Submission regarding Planning Proposal
Application No SSD-10473 Marist Catholic College
Location 264 and 270 Miller Street, North Sydney

1 CARLOW ST ELEVATION

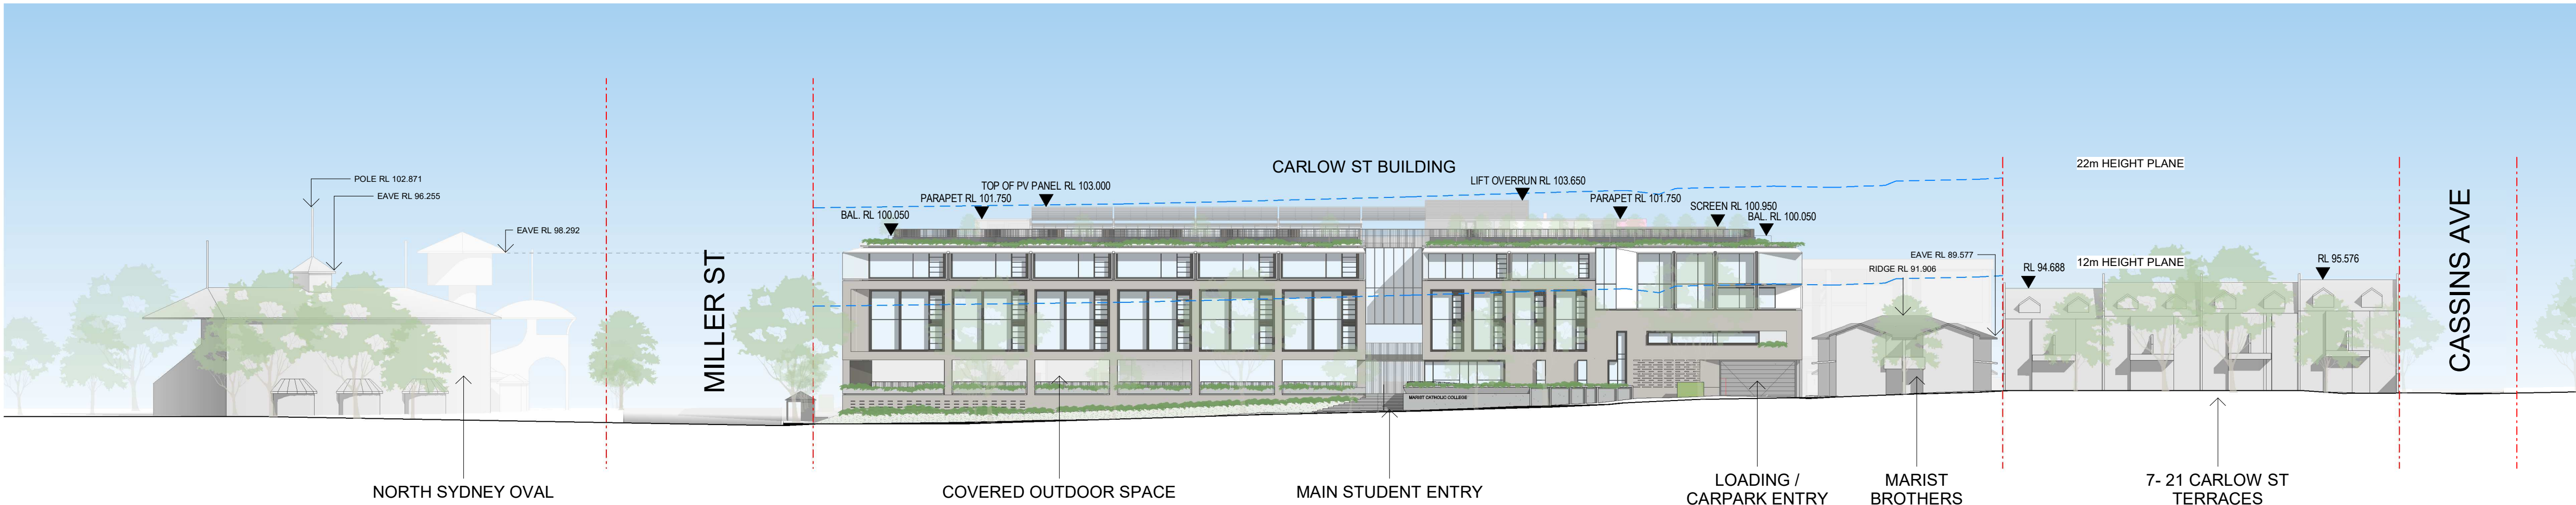
1. The height of the proposed buildings, especially the 5 storey building at the corner of Carlow and Miller Street (that will extend along Carlow Street as far as the residential properties) is too high.

I understand that clause 4.3 of North Sydney Local Environment Plan 2013 establishes a maximum building height of 12 metres. The height of this proposed building is approximately 21 metres – an enormous 9 metres over the recommended height.

Title
SHADOW DIAGRAMS - MID
WINTER

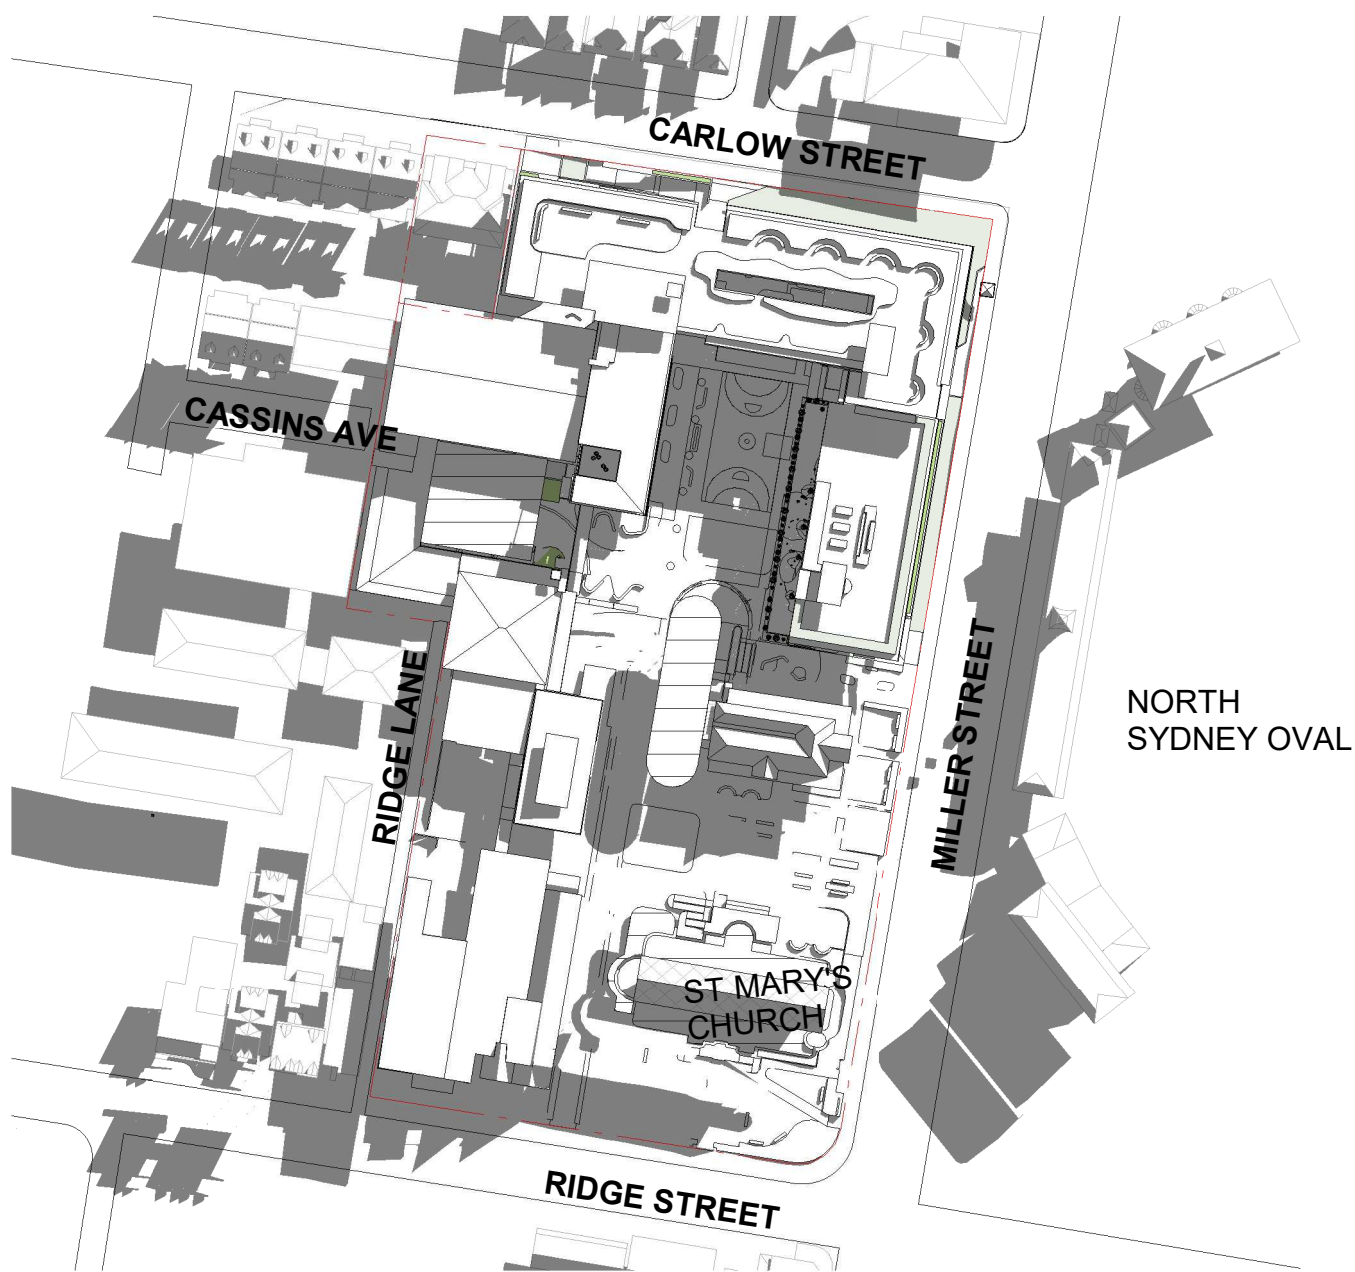
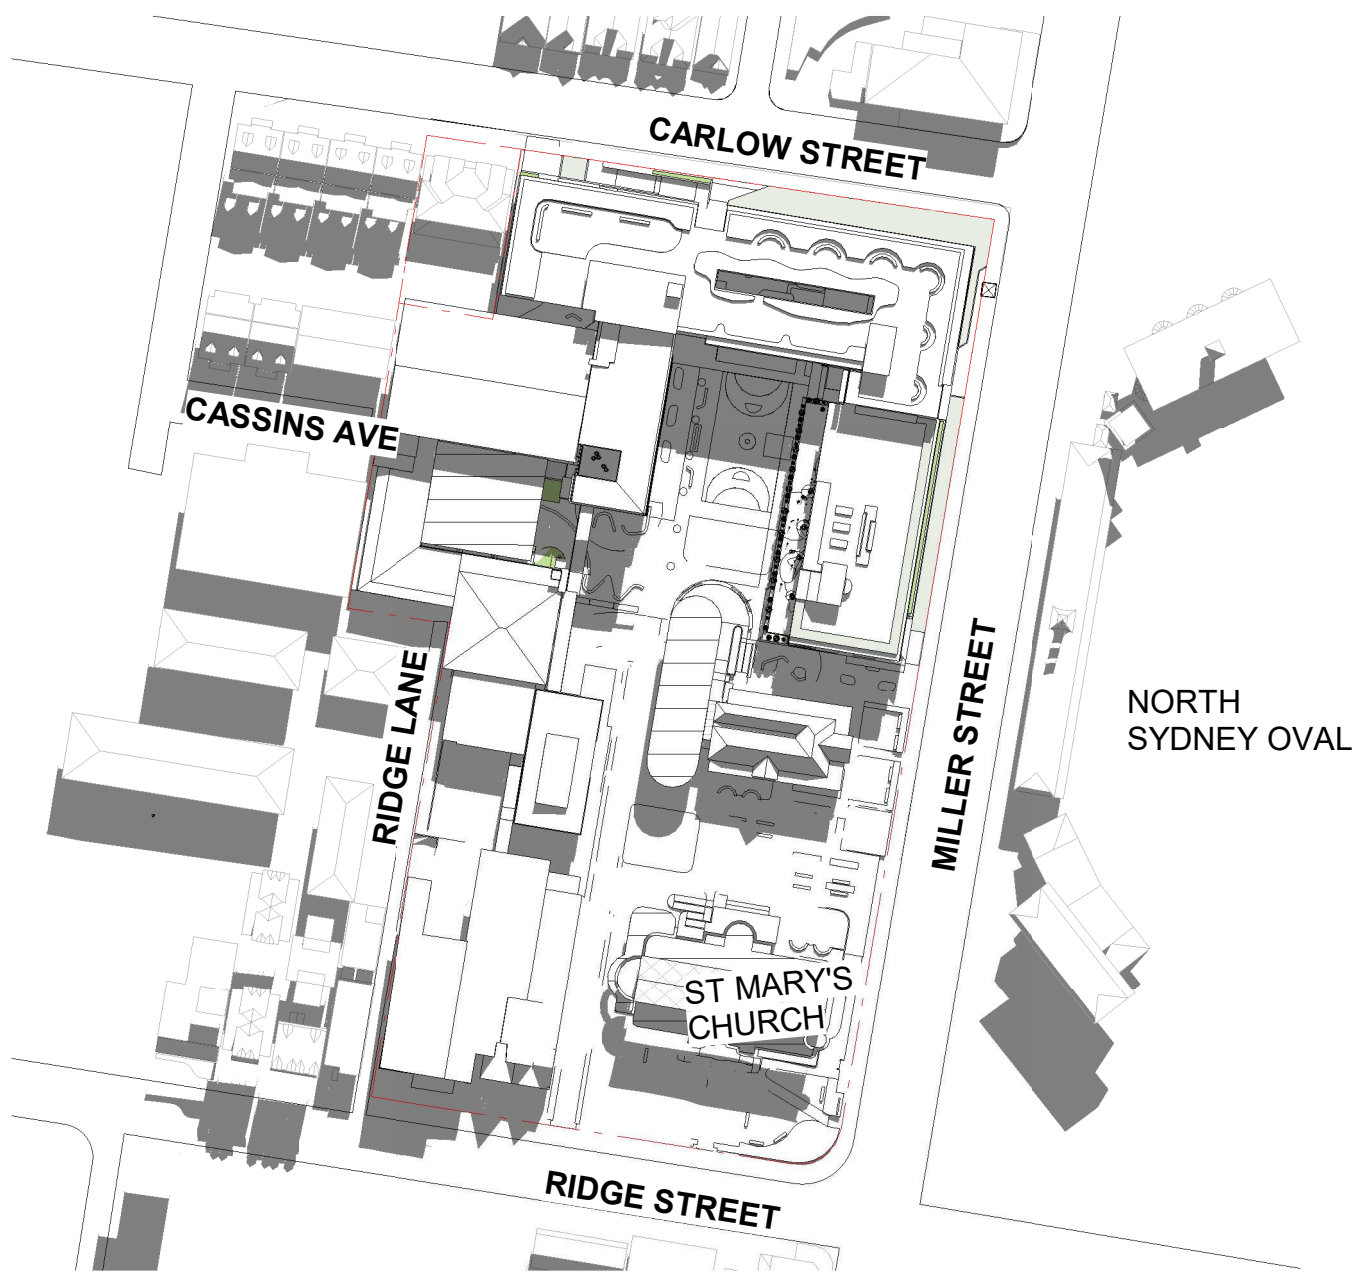
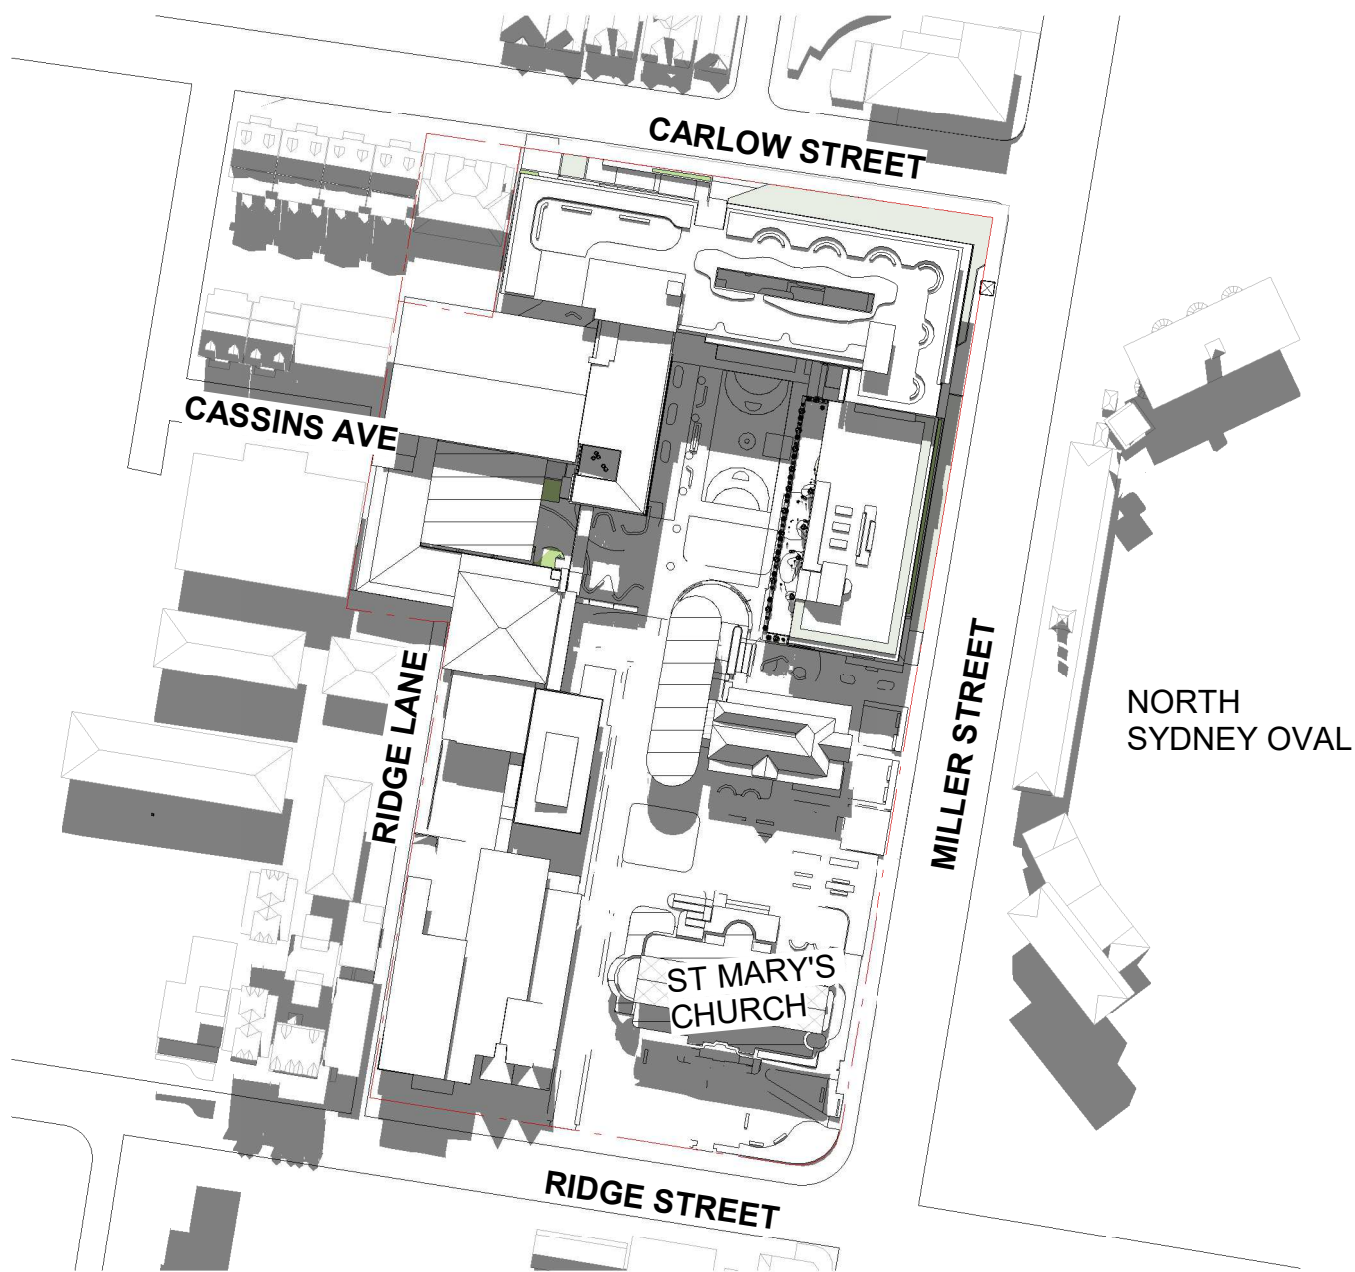
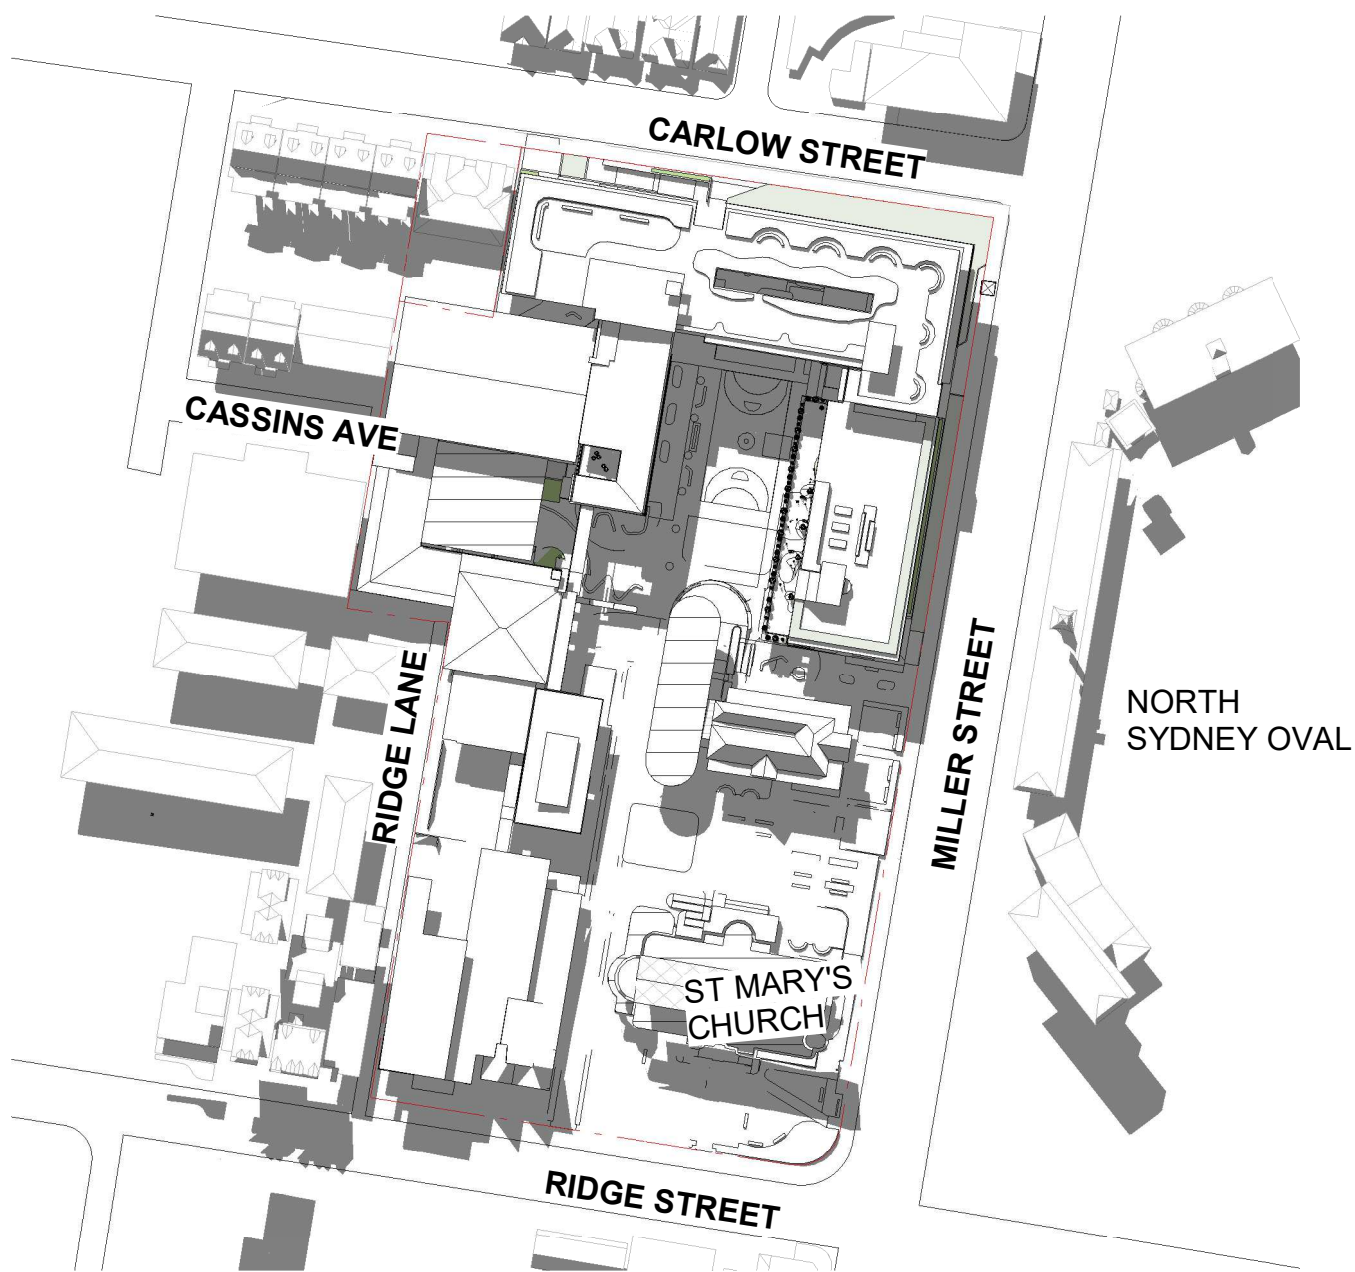
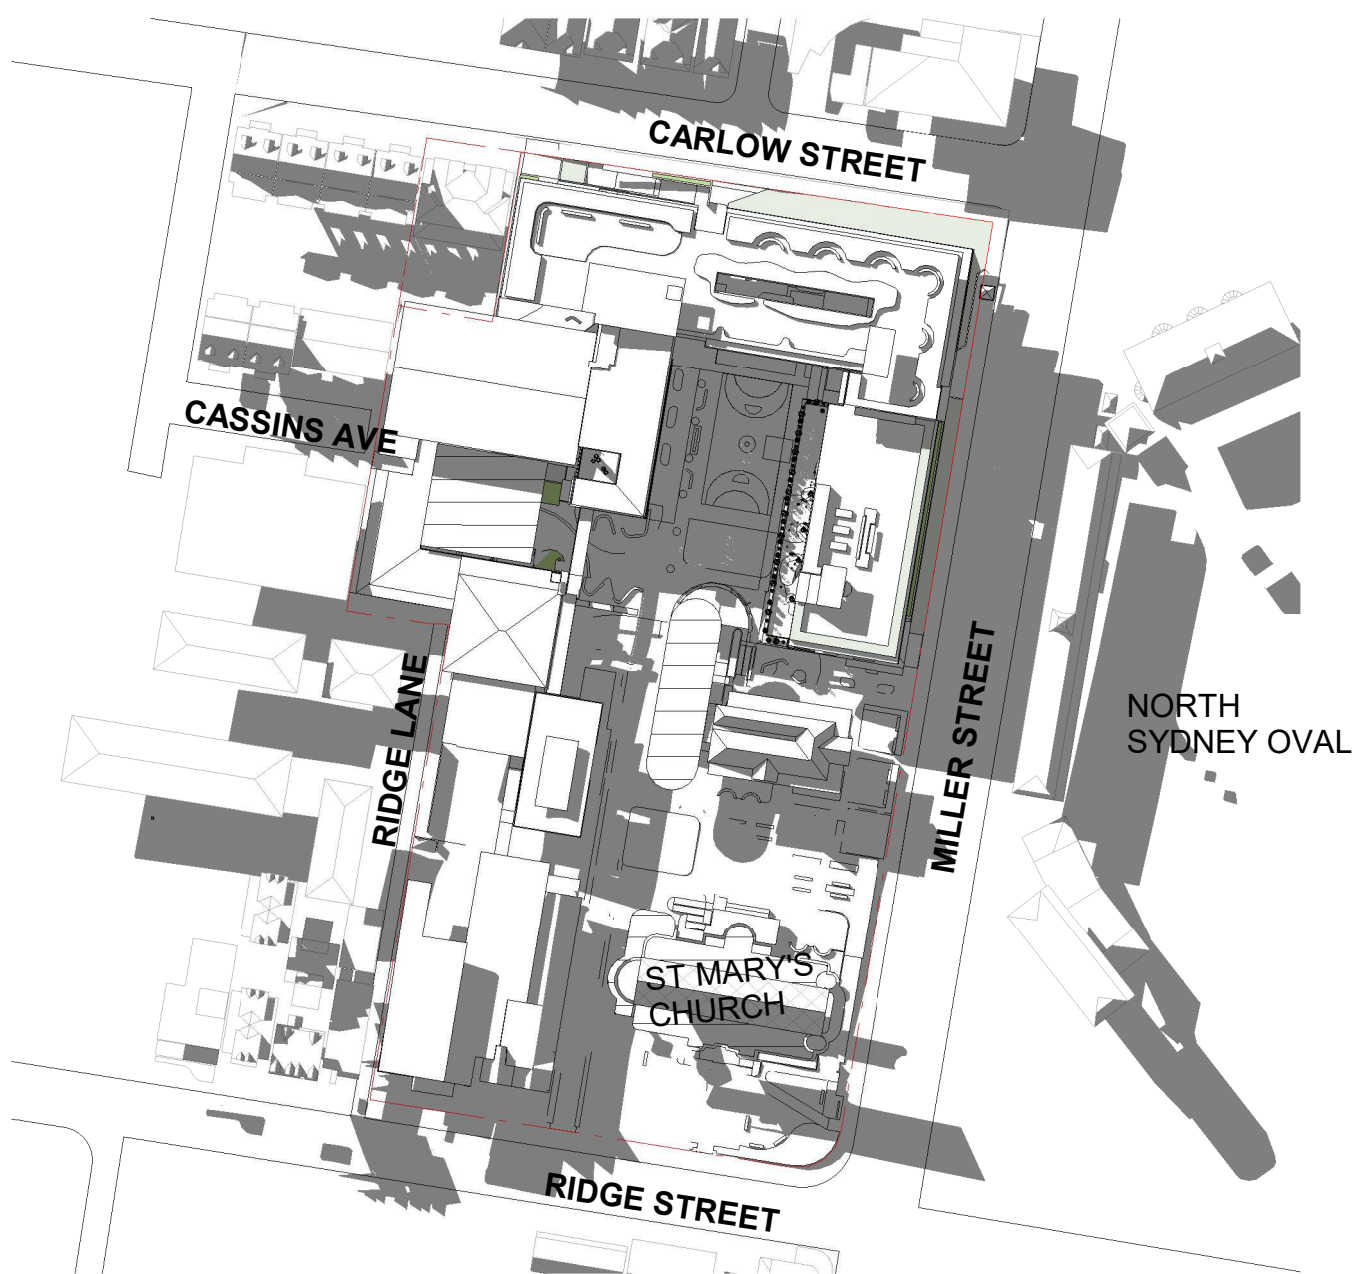
The plans show that the windows and balconies on the western side of this massive building will have direct sight into my backyard. Also I cannot believe that this building will not block some of our sunshine at certain times of the year. The shadow diagrams are shown for mid winter.
